Ribble Valley Borough Council
Housing & Development Control

Application no: **3/2021/1030**

Address: **The Annexe The Cottage Barn Chapel Lane Newton BB7 3DY**

Proposal: **Temporary change of use for a period of 2 years from extended family accommodation to self catering holiday accommodation.**

The Cottage Barn, Chapel Lane, Newton, Lancashire, BB7 3DY

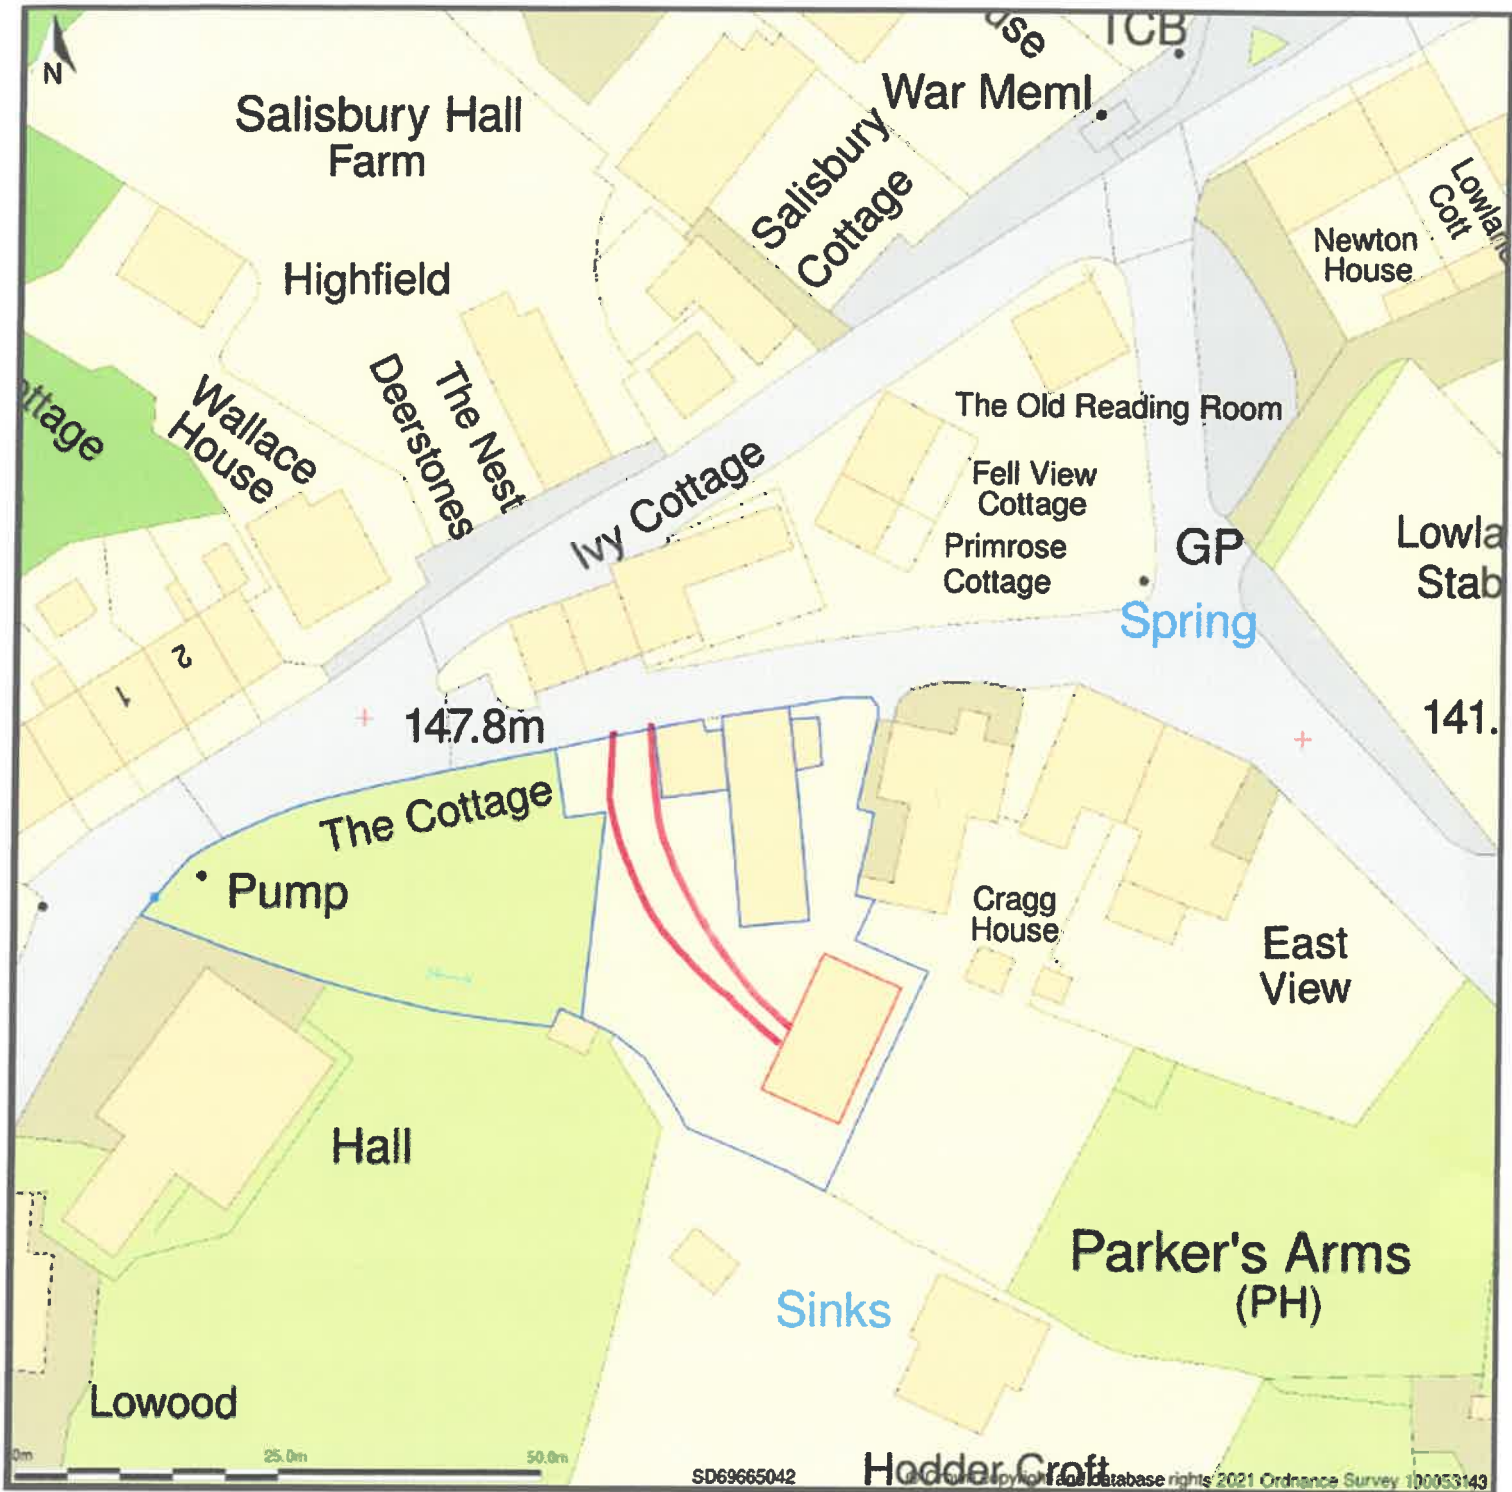
The LHA understands that the access, which can be viewed on the Buy a Plan drawing titled "Location Plan" currently serves the annexe and the main dwelling at the site. Therefore, with the site access already being existing the LHA have no comments to make.

Address	Annex Newton in Bowland BB7 3DZ		
Drawing Title:	Existing First Floor	<i>2 PROPOSED,</i>	
Drawing No:	Newt/01/A	Scale:	1:100 at A4

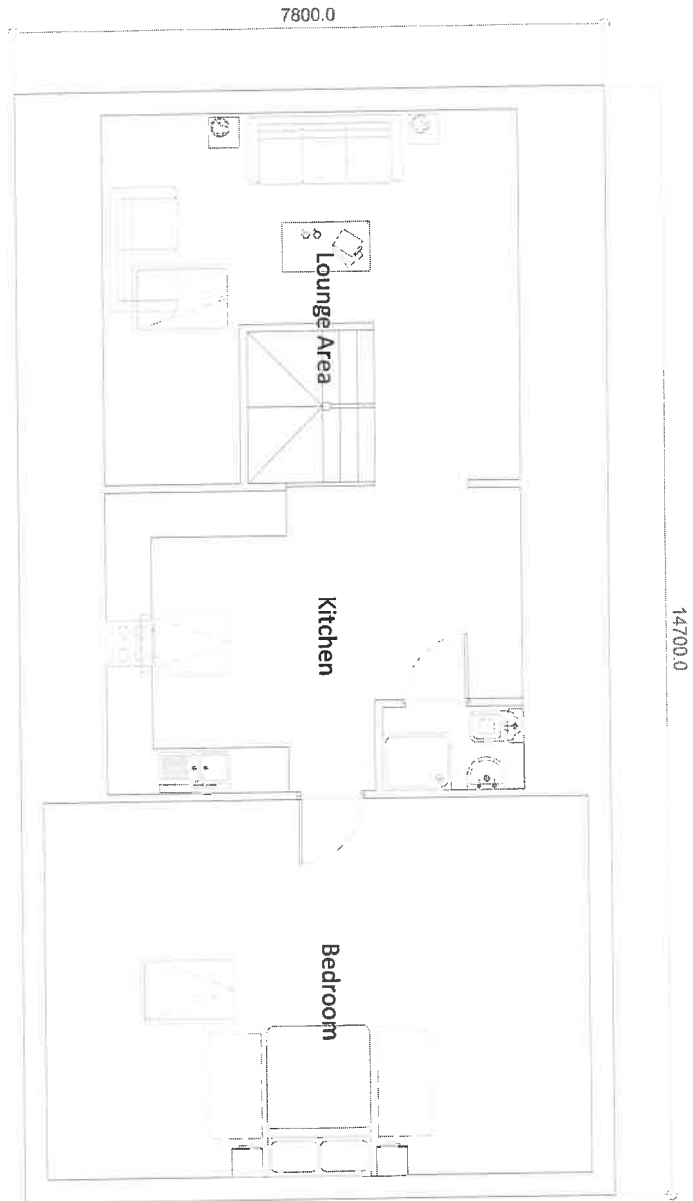
The LHA have reviewed drawing number Newt/01/A titled "Existing First Floor Proposed" and understands that the annexe is a one bed and has access to a single garage which can be used to serve the holiday home for parking. Therefore, the LHA are satisfied that the site complies with the LHAs parking standards as defined in the Joint Lancashire Structure Plan and so have no objection to the proposal.
